Planning Application Ref: R/203/21/PL

Location: Booker Hall, Station Road, Rustington, BN16 3AY

Description of works: Demolition of existing community hall and ancillary building and redevelopment of the site to provide a new community hall with supporting functions and office accommodation within a new 1.5 and 2 storey building with associated car parking area and landscaping

Mark Warwick
Tree Officer / Parks and Greenspace Team

Tree and Vegetation Management

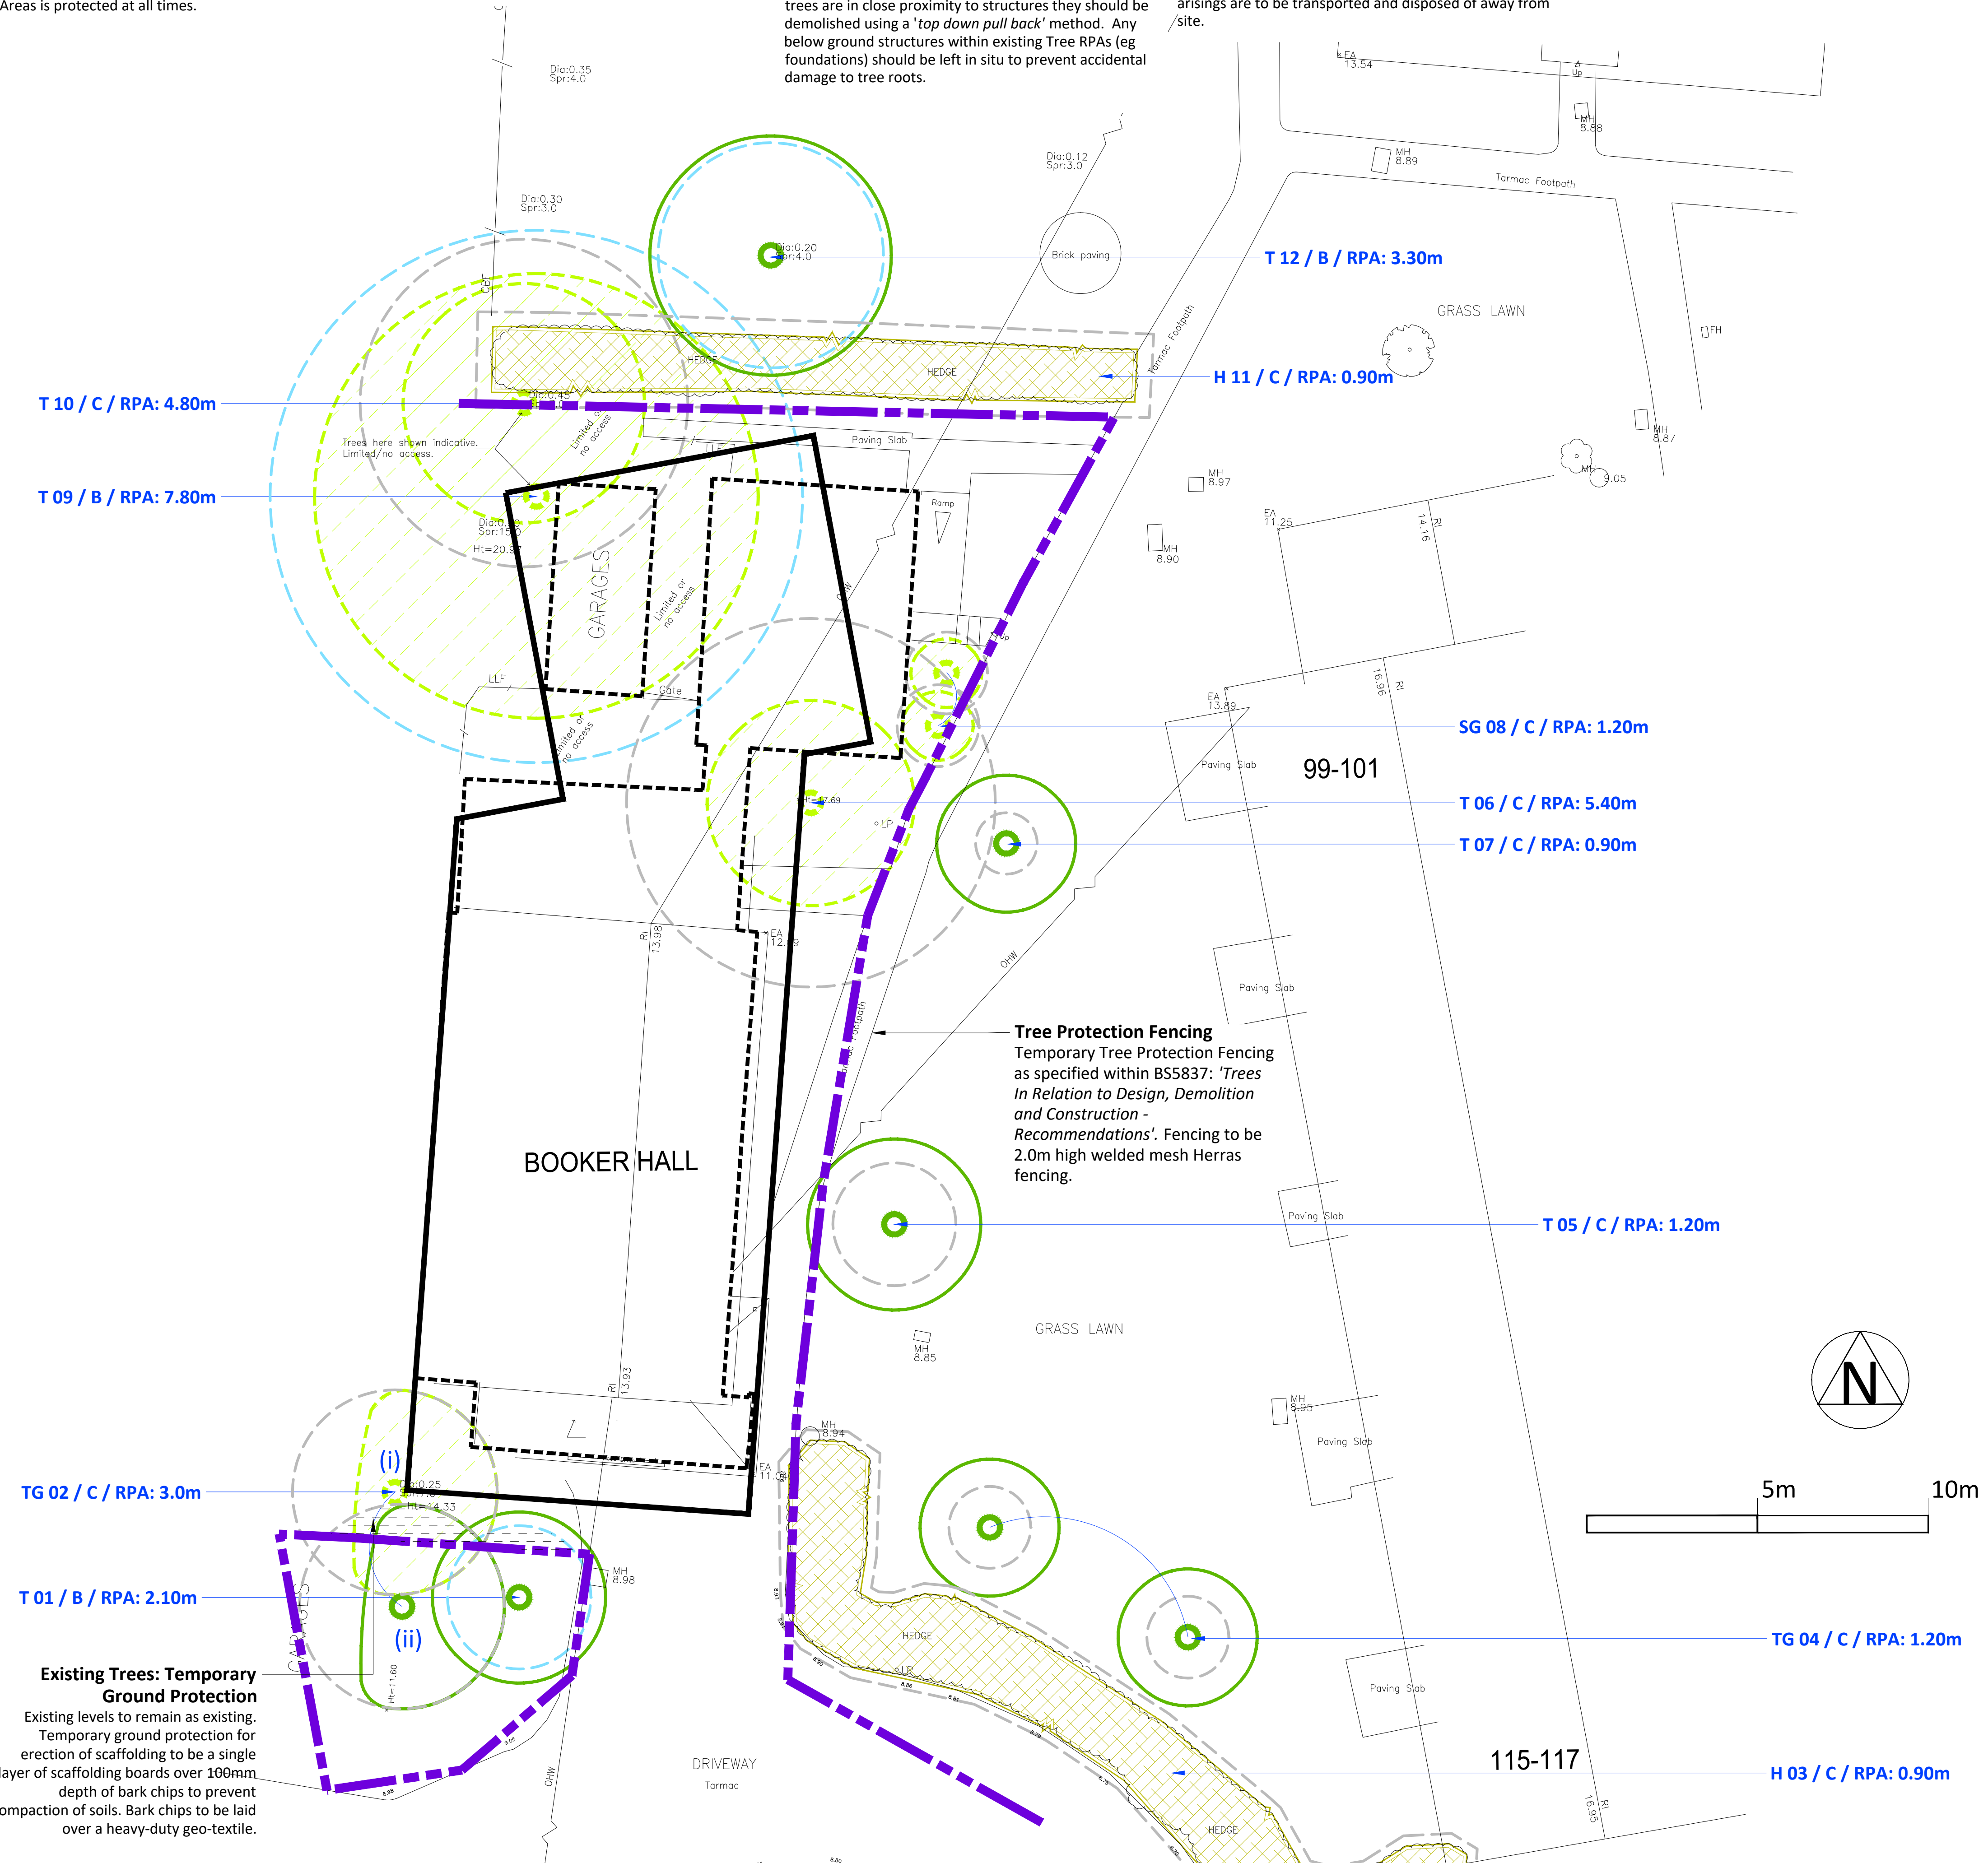
- The applicants have employed Ramsey & Co Landscape Architecture to prepare a Landscape Drawing Issue Sheet and Tree Schedule (Arboricultural Report) along with a Tree Protection Plan for this project.
- Although presentation of arboricultural information is not typical for detailed planning applications; the Tree Survey data is comprehensive and accords with the requirements of BS5837:2012. Method Statement for works in proximity to retained trees on or overlapping the site is included at the foot of the report and appropriate for the scheme. Note: this applies only to the Community Hall / Ancillary Building redevelopment proposal.

- Trees existing on the site are of relatively low public amenity value and several are probably no longer suitable for their location. No soft landscape proposal as mitigation has been submitted.

- The Community Hall / Ancillary Building redevelopment proposal is supportable in arboricultural terms, although it is disappointing not to see a soft landscape proposal (as mitigation for established tree removal) when opportunity exists at the land parcel rear of 5-7a Paddock Green. A small area set aside in the NE corner, recovered to open ground (enhanced by planting) would be ideal and act as future root protection for the off-site birch tree (TPO/R/1/18) in rear garden of 7a. **Soft landscaping is only an aspiration at this stage, no detailed proposals have come forward. Nominal RPA of the off-site birch tree has now been adequately respected, with recovery of compacted ground to greensward/plant border.**

-
- I recommend the above scheme for **APPROVAL**, subject to the following conditions being applied:
1. Before the site is occupied or any machinery is introduced to the site or demolition work or construction work or alterations to existing ground levels takes place, written confirmation is required from the Arboricultural Expert representing the site owner(s), confirming that all protective fencing (minimum specification as per Figure 3 of BS5837:2012) and ground protection has been inspected and found to be 'Fit for Purpose' as required under British Standard 5837:2012 and been erected and positioned exactly as shown on the following Tree Protection Plans:

- **Tree Protection Drawing, Ramsay & Co Landscape Architecture, dwg. RCo350-02 Rev 01**
